From: Anita Gardner
Sent: 14 February 2018 14:06
To: Karen Parsons
Subject: FW: 93 Middleton Road application numbers M/123/17/HH and M/133/17/HH

To address your design concerns, I have modified the original scheme shown on applications numbers M/123/17/HH and M/133/17/HH in the following aspects:

SECTION E:E

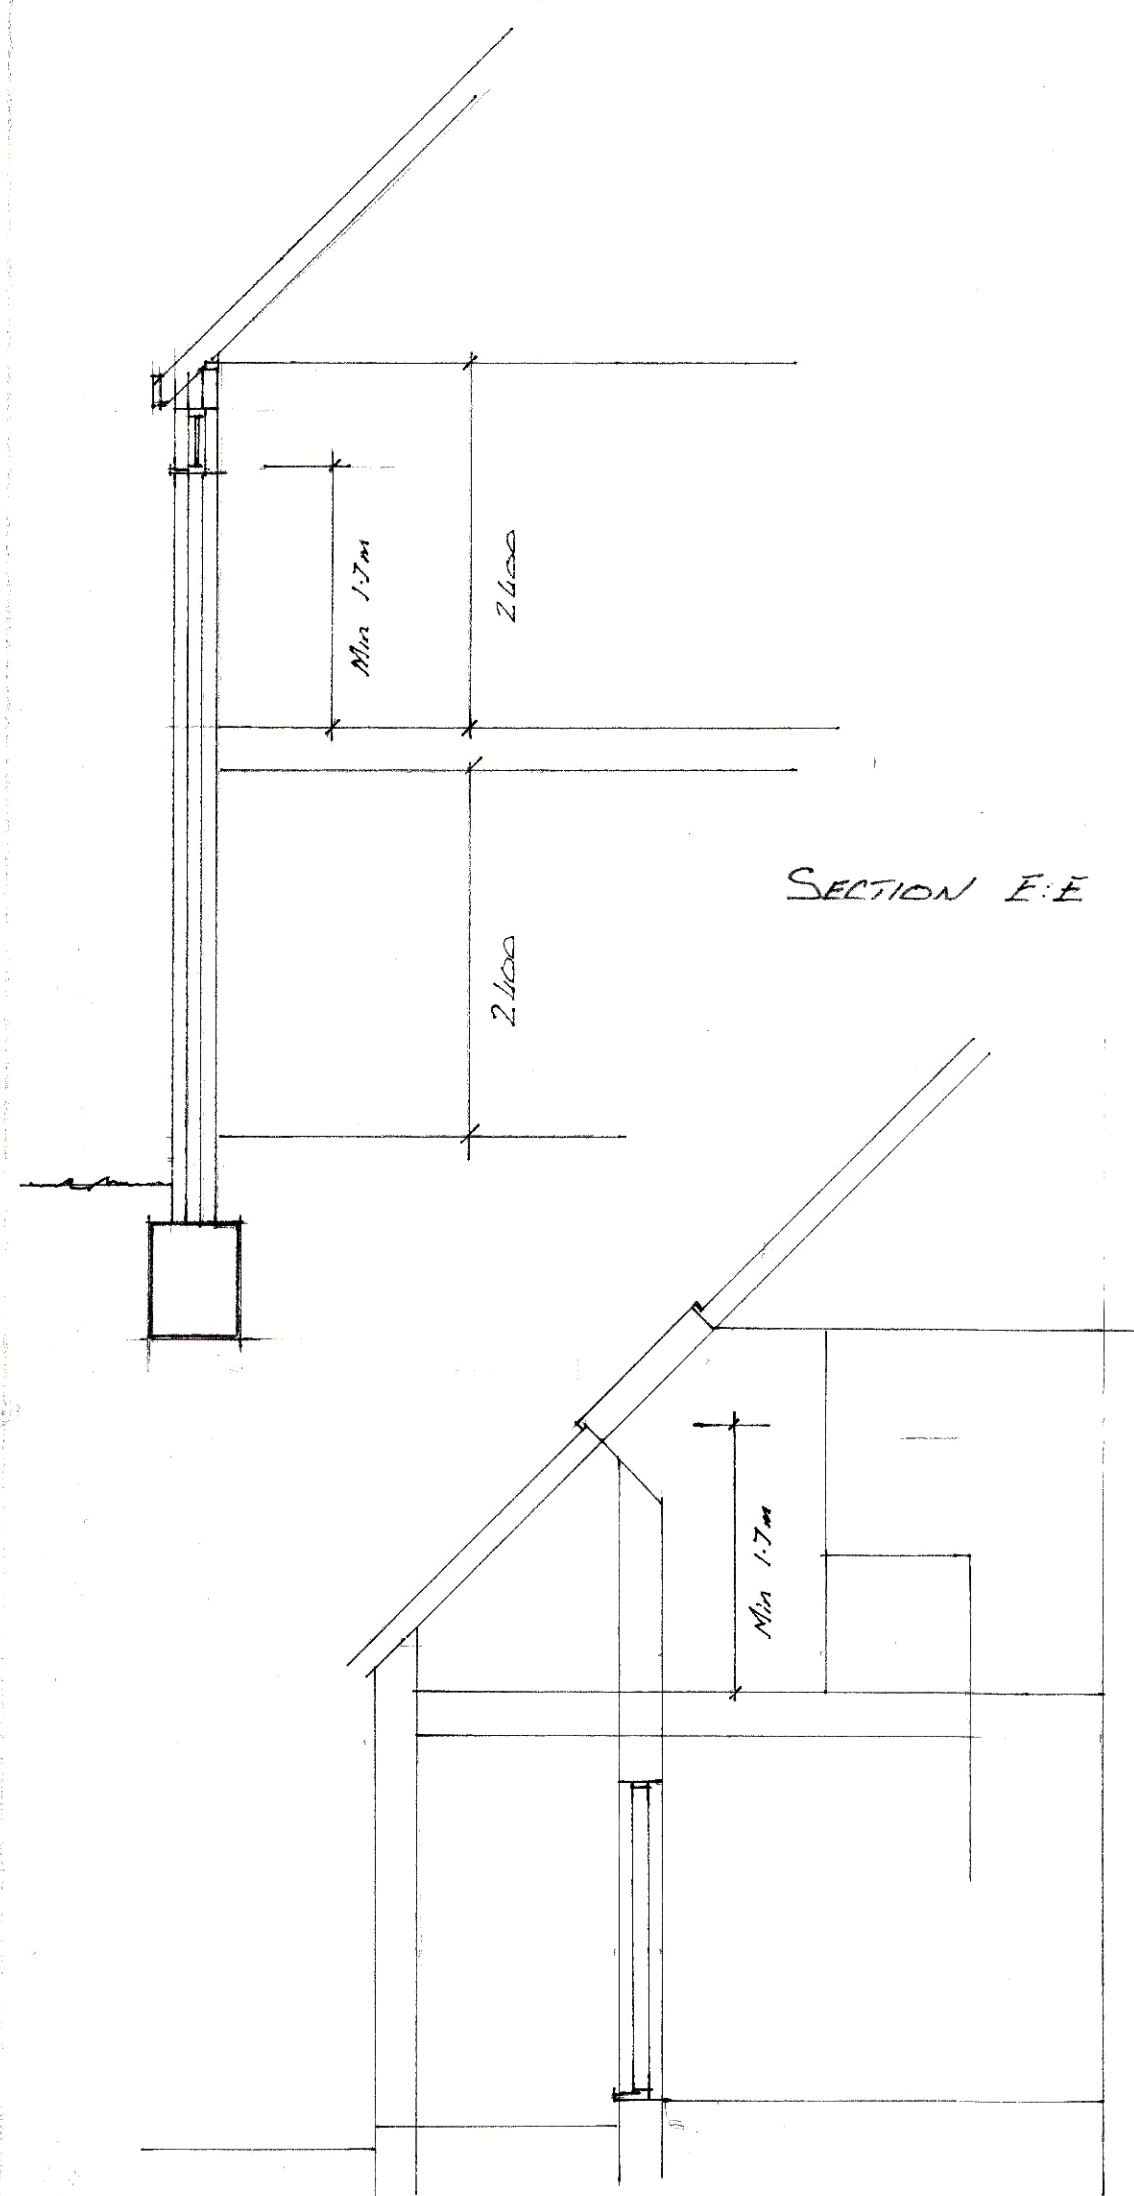
3. Reducing the ridge height on the east side of the building from that shown on the previous scheme
4. Only having one high level window on the east elevation (see section E on drg no AB 100 11C)

DRC N°: AB: 100 12

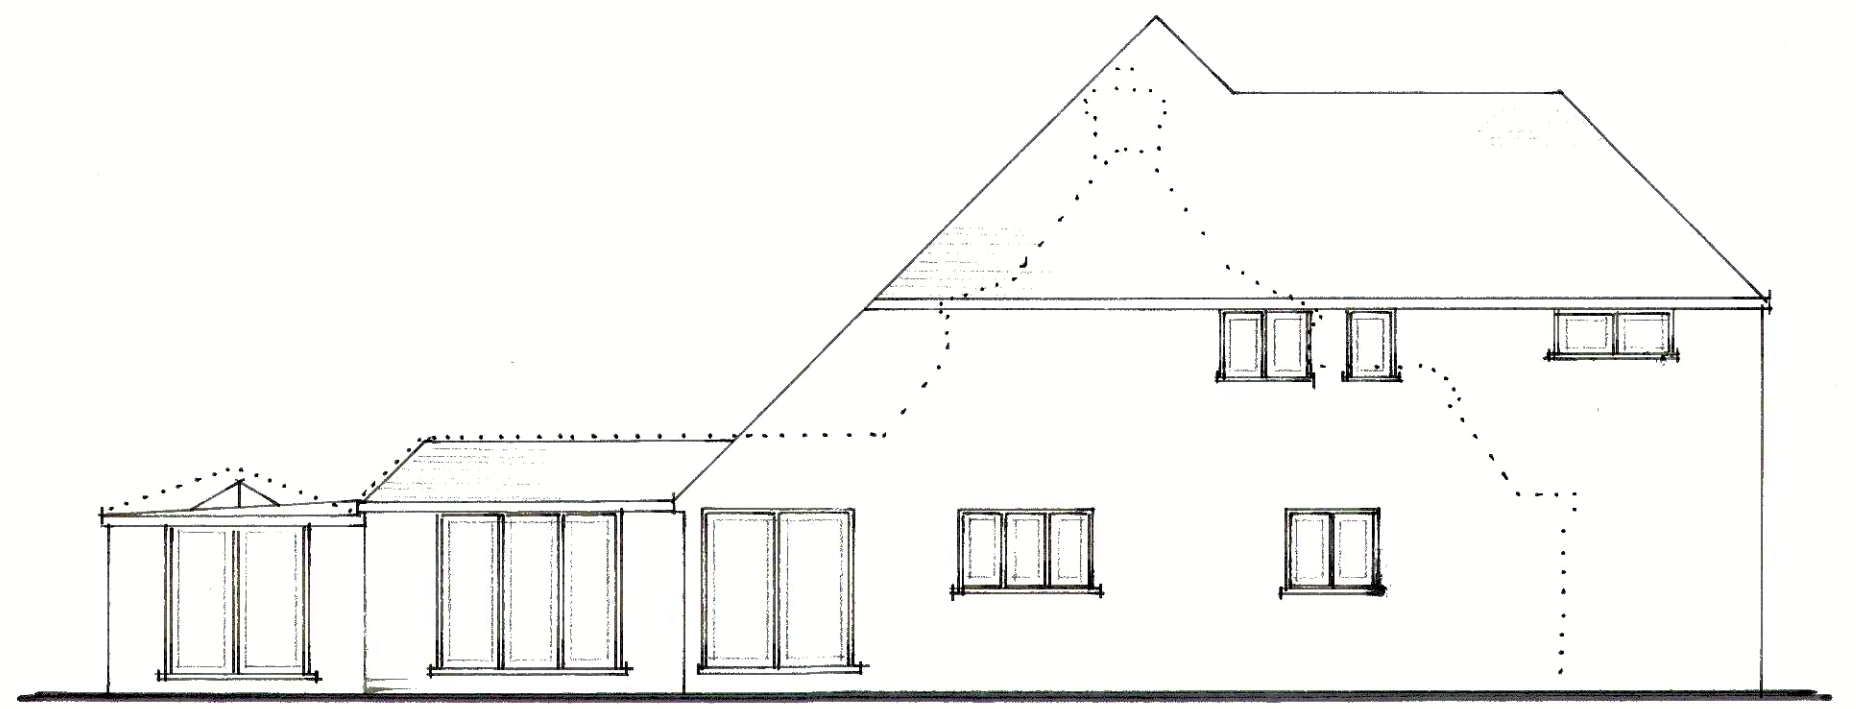
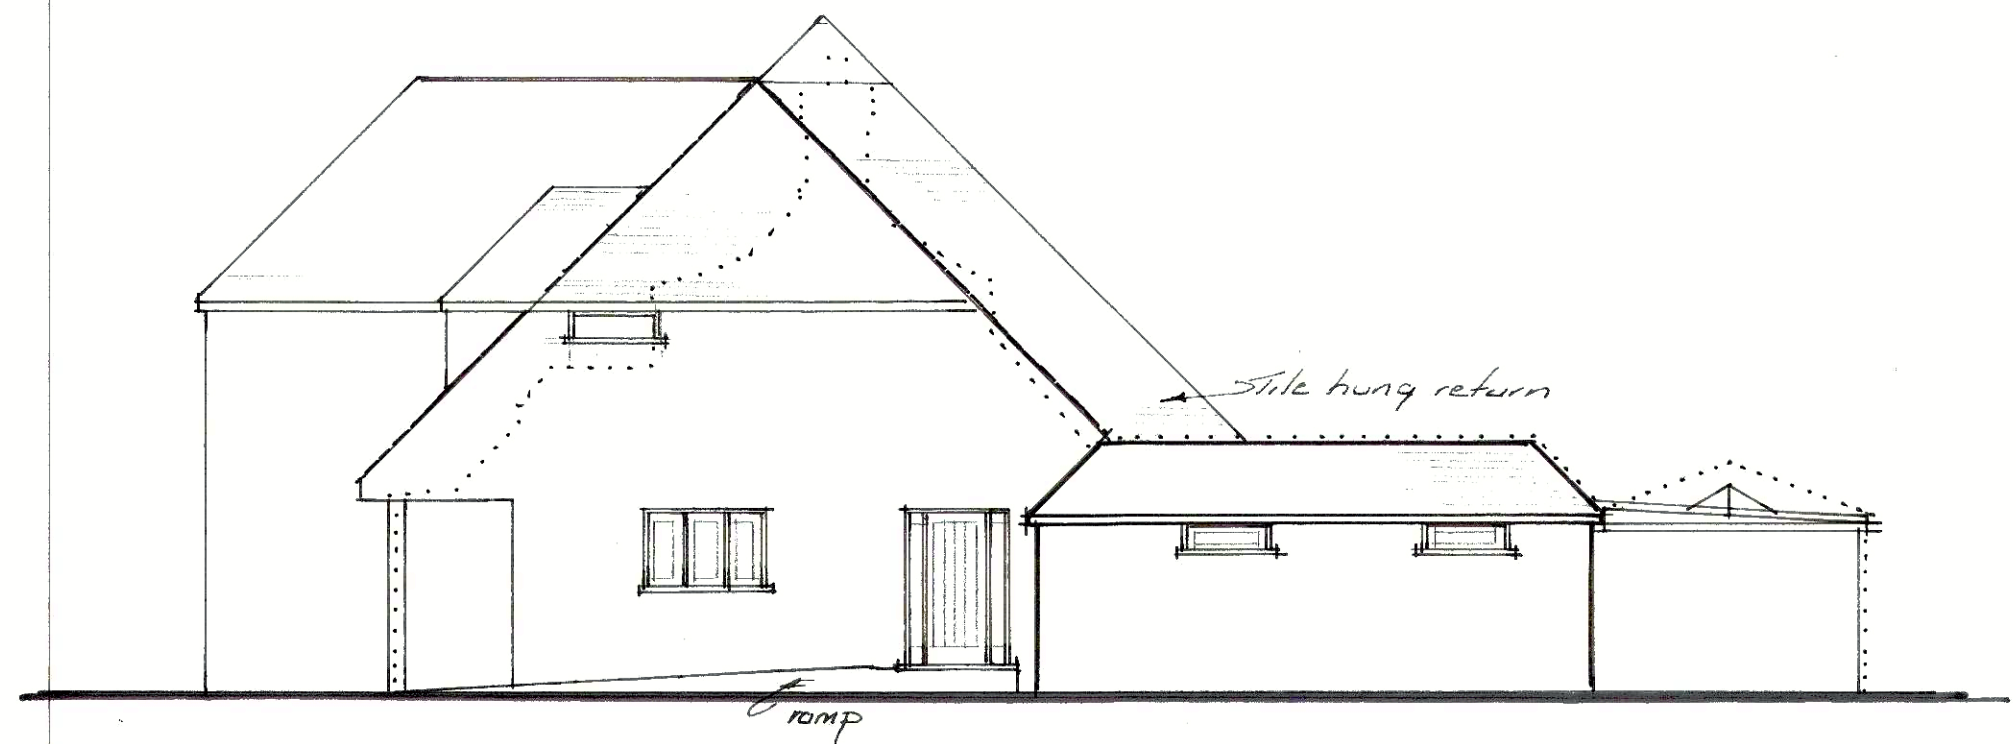
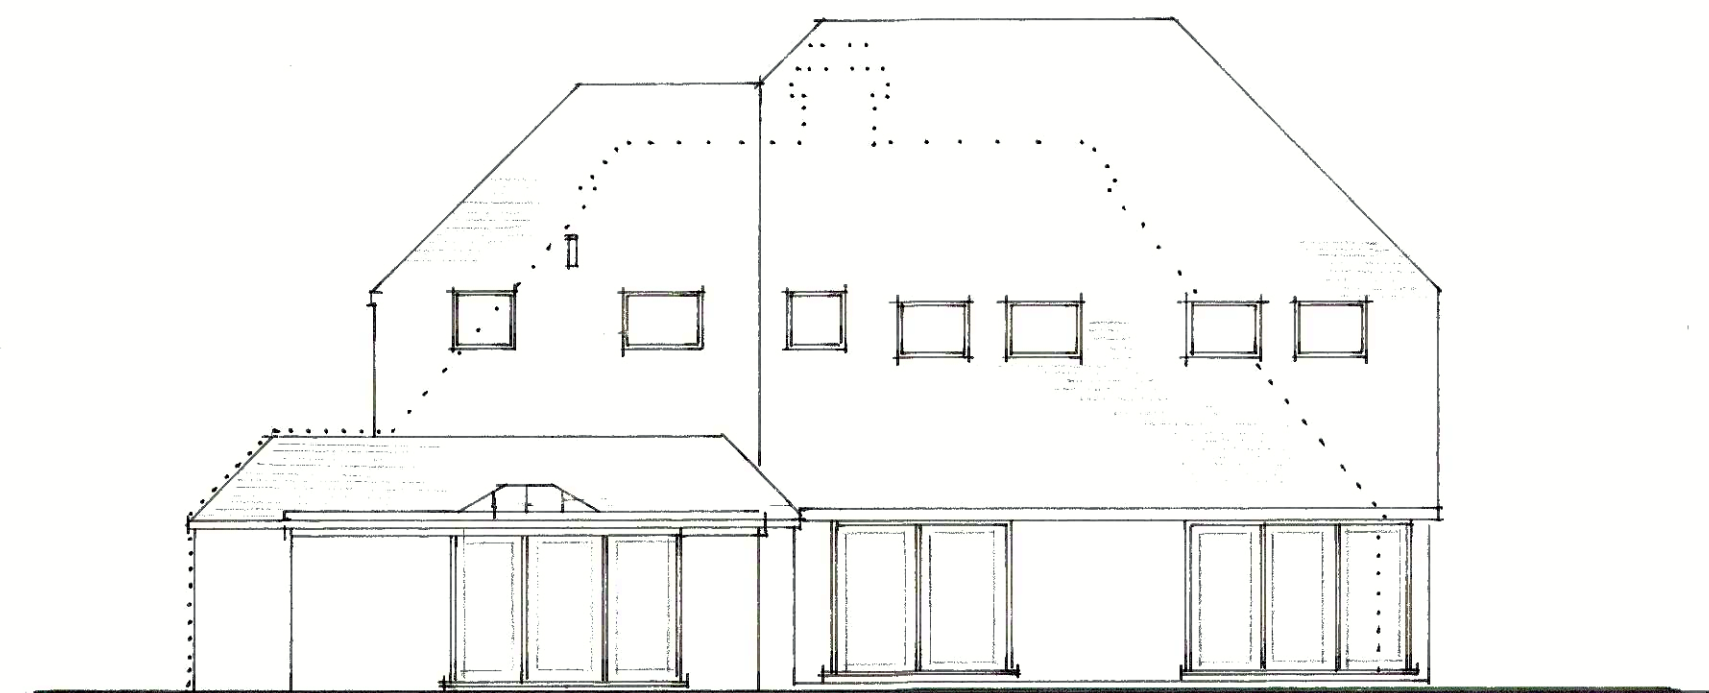
12. I have dotted the existing building outline on drawing number AB 100 12
13. To assist with your review of the street scene, I will send another email with photo shots of the adjoining properties.

1. Moving the bulk of the extension to the front of the property predominantly on the south west side of the existing building.
2. Removing the cat-slide roof feature shown on the east elevation of the previous scheme

7. Not changing the position, structure or windows of the existing annex construction on the east elevation.
8. Moving the rear entrance door further from the east boundary than on the previous scheme

10. Replacing the large windows on the north elevation, as shown on the previous scheme, with velux type windows.
11. Lowering the roof of the conservatory by constructing a flat roof structure
